A57 Link Roads

**9.13 Draft Statement of Common Ground
with Peak District National Park Authority**

9.13 DRAFT STATEMENT OF COMMON GROUND WITH PEAK DISTRICT NATIONAL PARK AUTHORITY

Table 3.2: Table of Issues/Matters - Final Version dated 6th January 2022.

**6.4 Environmental Statement
Figure 5.1 Air Quality Constraints Map**

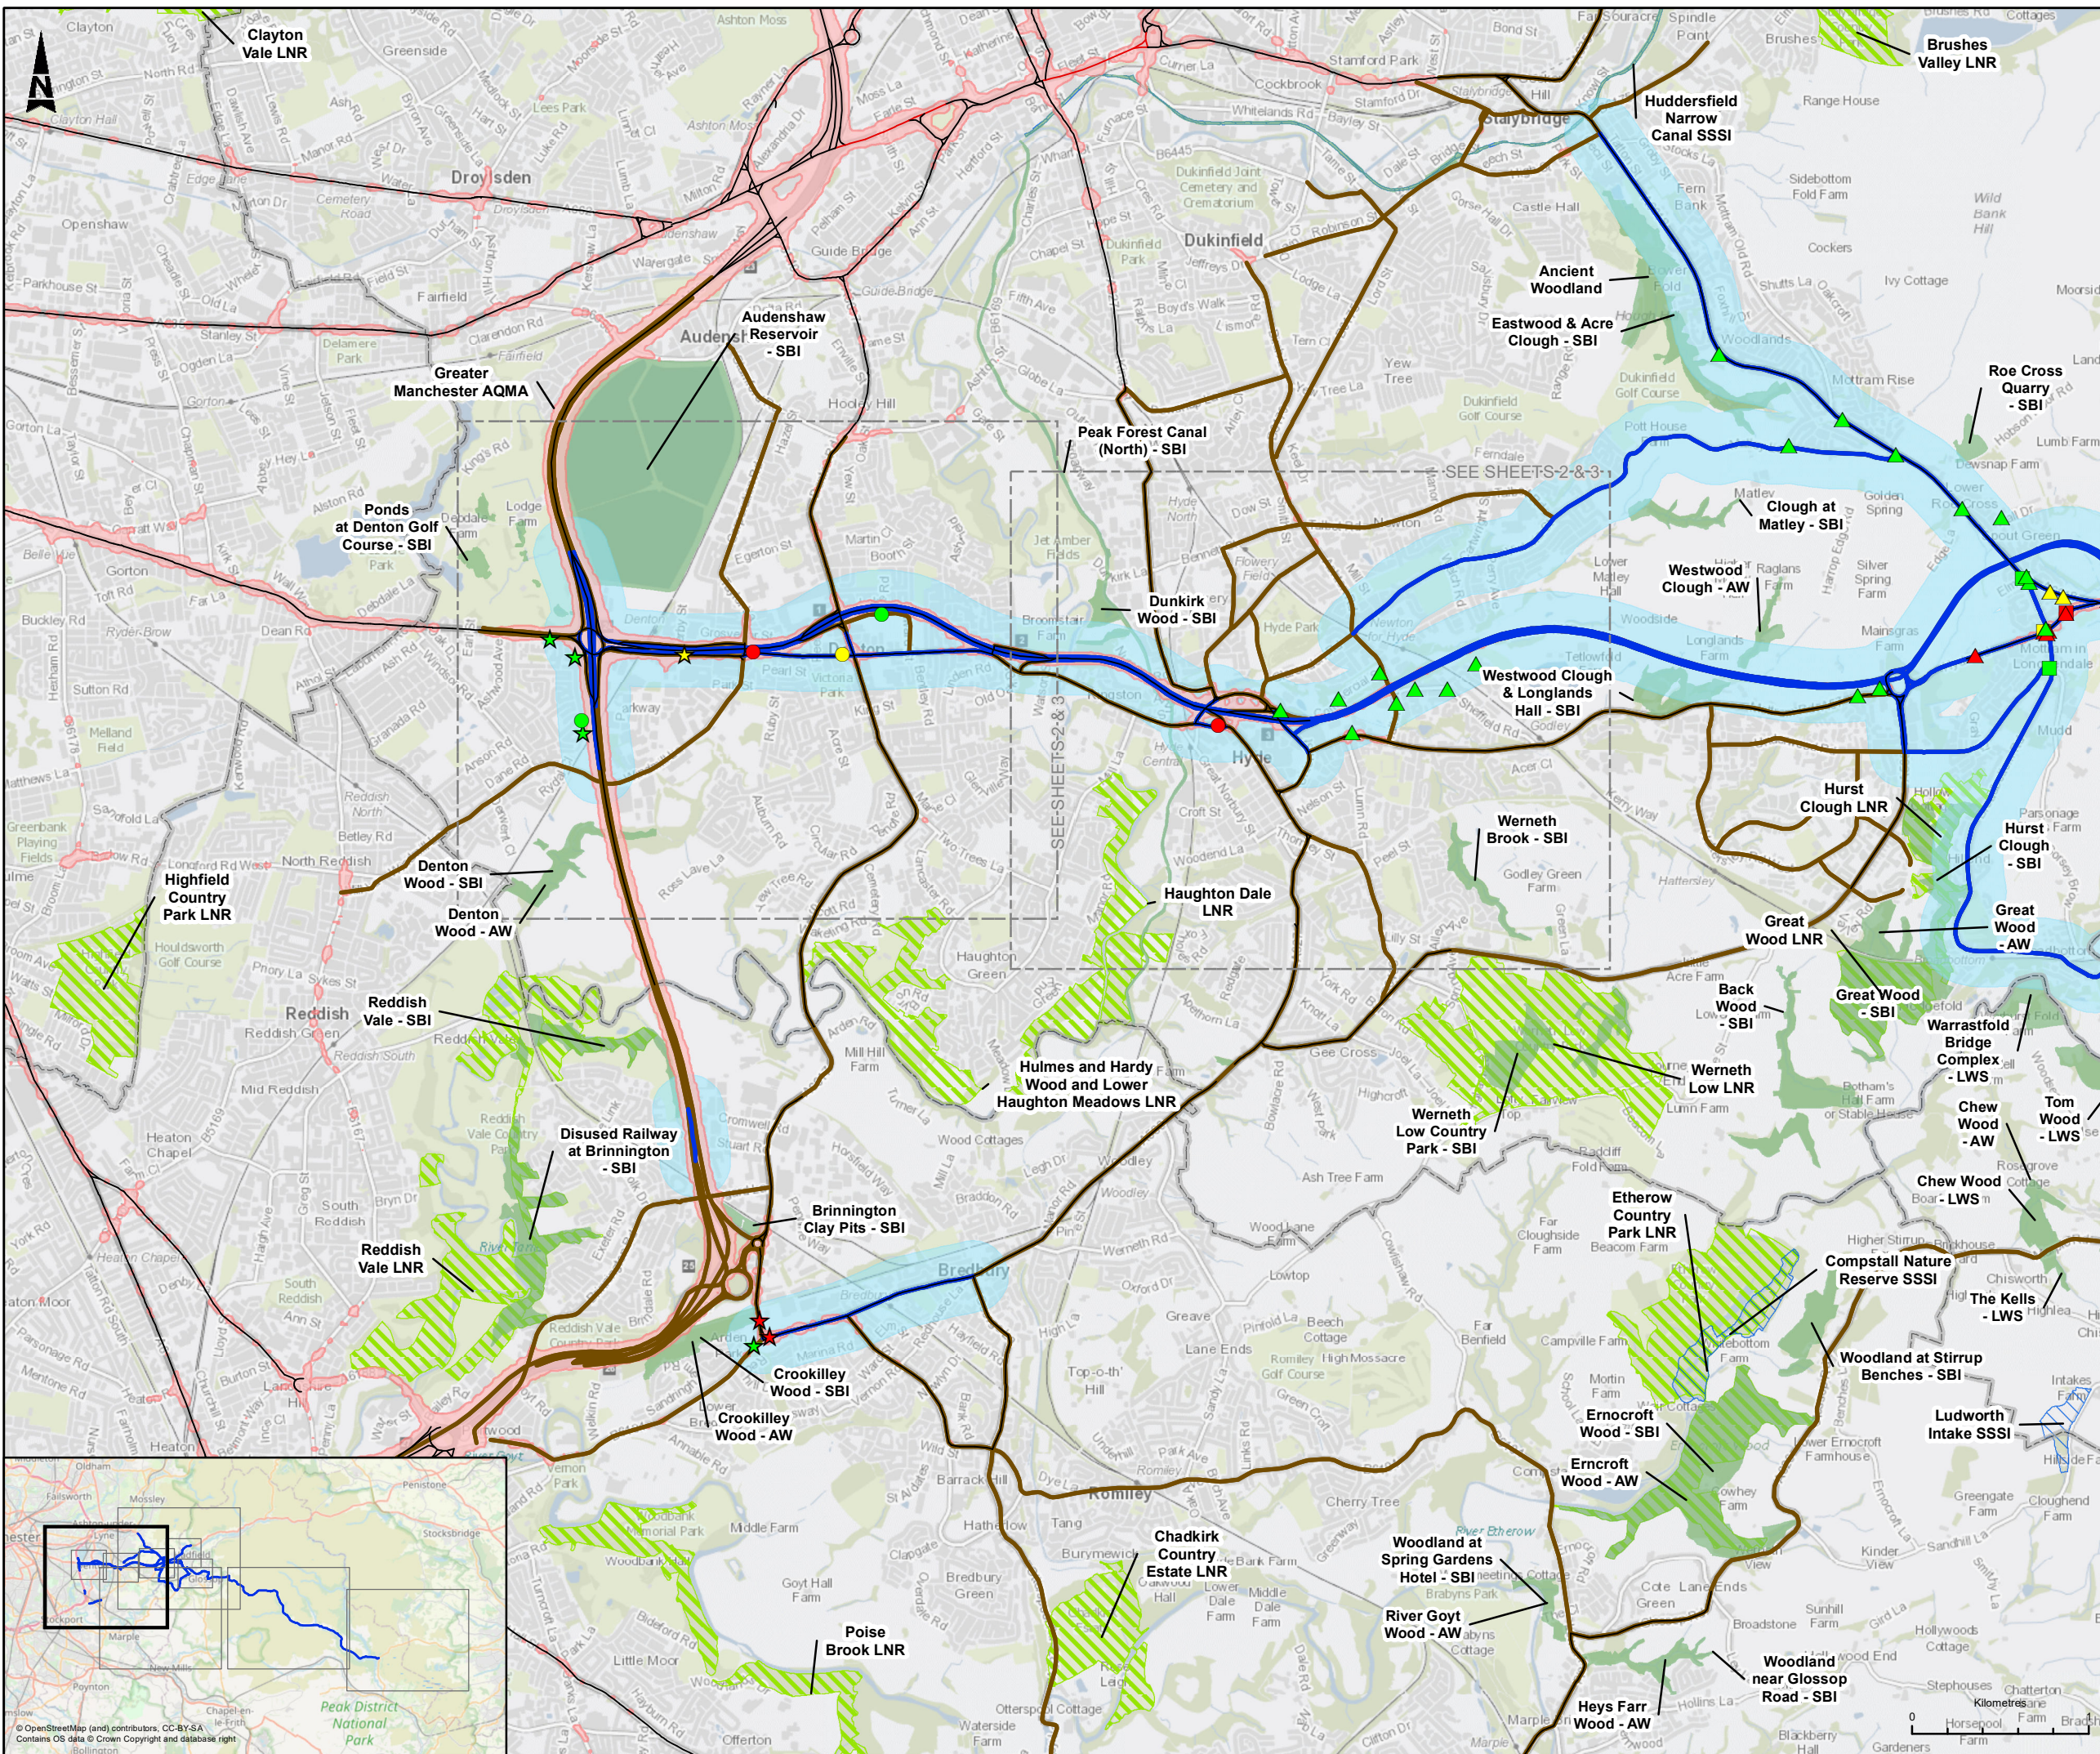
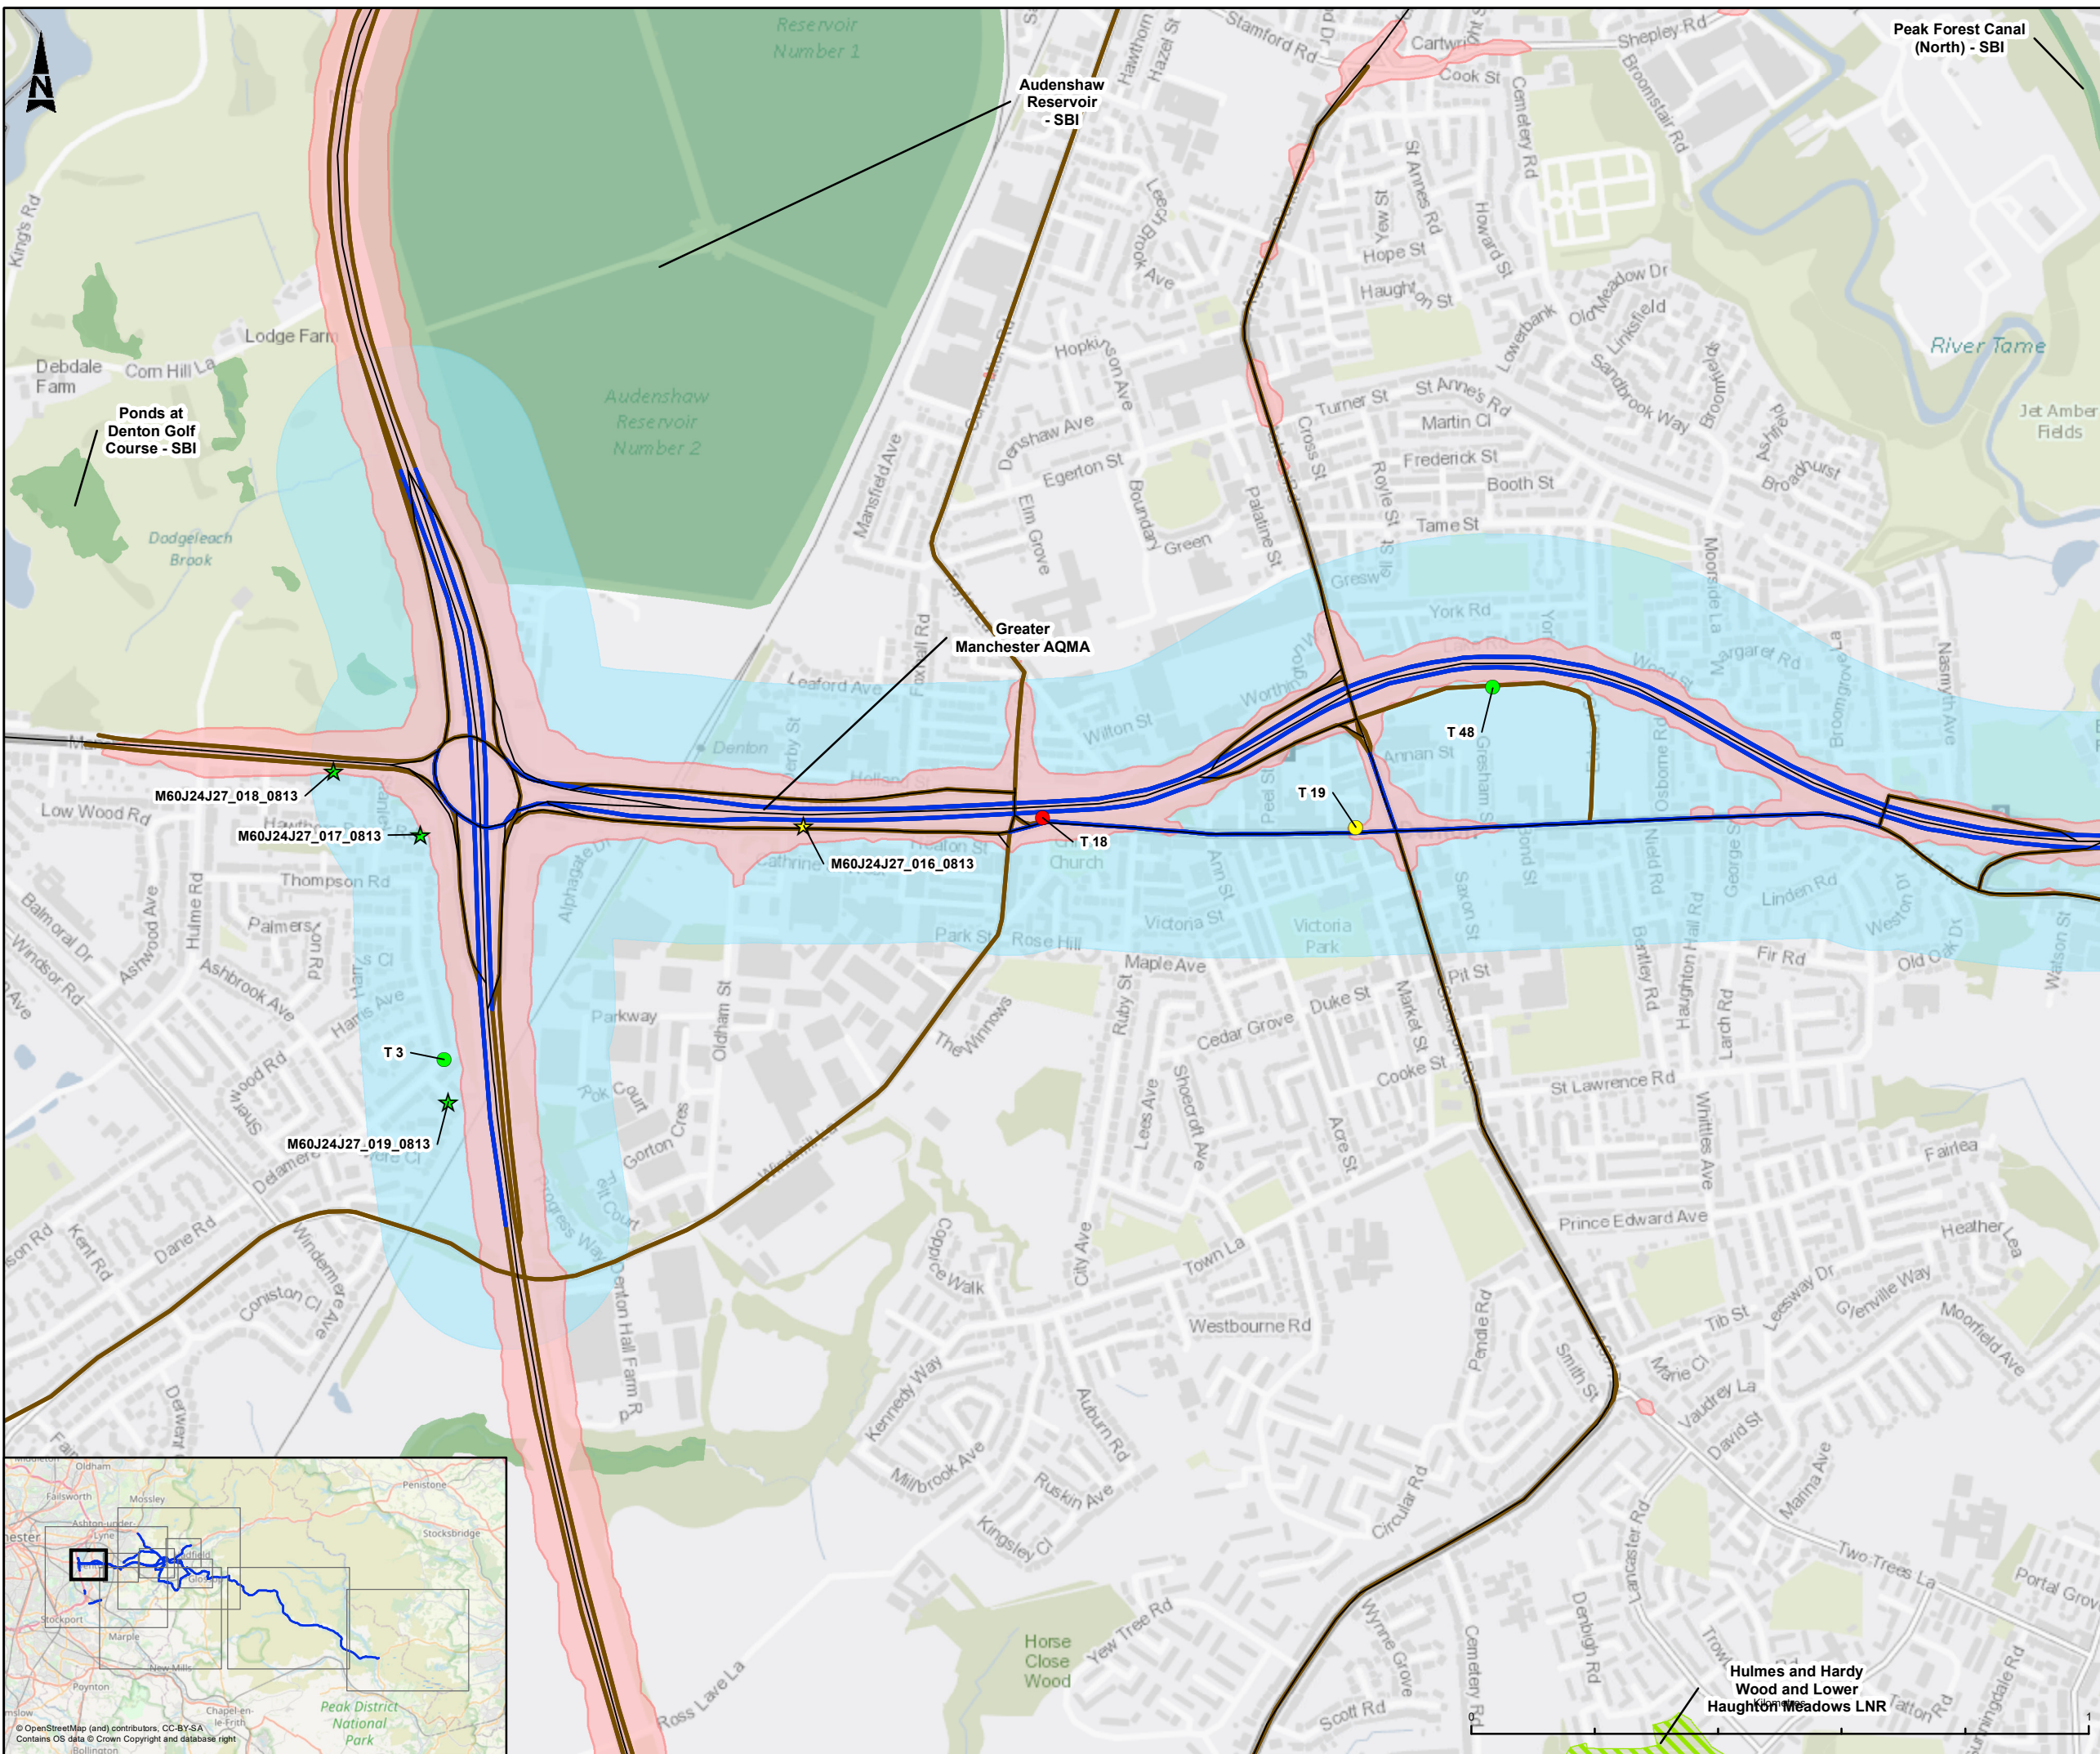
2.3.1	ES Chapter 5: Air quality (APP-061)	Effects on air quality and designated sites	<p>From the PDNPA Relevant Representation (RR-0677-3):</p> <p>We have concerns regarding the effects of the scheme on the following:</p> <p>1) Air Quality a) Tintwistle AQMA –is acknowledged within the ES, however, there is no assessment of the effects of the predicted increased traffic flows on it.</p> <p>b) Designated sites (A628) – are already subject to high traffic flow and associated Nitrate deposition. Whilst predicted increased flows for 2025 do not meet the 1,000-vehicle threshold, we believe that an assessment of impact should have been undertaken.</p>	<p>National Highways response to PDNPA Relevant Representation (RR-0677-3):</p> <p>The study area for the assessment of impacts on air quality of the operational phase of the Scheme has been determined in accordance with the National Highways Design Manual for Roads and Bridges (DMRB) LA 105 Air Quality standard, which ensures that the scheme can demonstrate compliance with the NPSNN. The DMRB LA 105 standard defines traffic change criteria for determining whether air quality impacts can be scoped out or require assessment (DMRB LA 105 paragraph 2.1) based on the changes in annual average daily traffic (AADT) flow, heavy duty vehicle (HDV) flows and speed. The key traffic change criteria are the flow change criteria - a change of over 1000 AADT and a change of over 200 HDV with the Scheme compared to without the Scheme in the Scheme opening year of 2025. The traffic change criteria has been applied to traffic output from the scheme specific traffic model to determine the Affected Road Network (ARN). The scheme specific traffic model includes strategic roads, including the A628 through the Tintwistle AQMA and ecologically designated sites. The extent of the ARN is presented in Figure 5.1 of the Environmental Statement (APP -076). The traffic change criteria are not exceeded for the A628 through the Tintwistle AQMA or for sections where there are ecologically designated sites adjacent and as a result is not included in the air quality assessment. Where traffic change criteria are not exceeded on roads they are not considered further in the air quality assessment. It is considered that impacts from a scheme on traffic flows below, this criteria is not considered to be significant.</p>	Under discussion
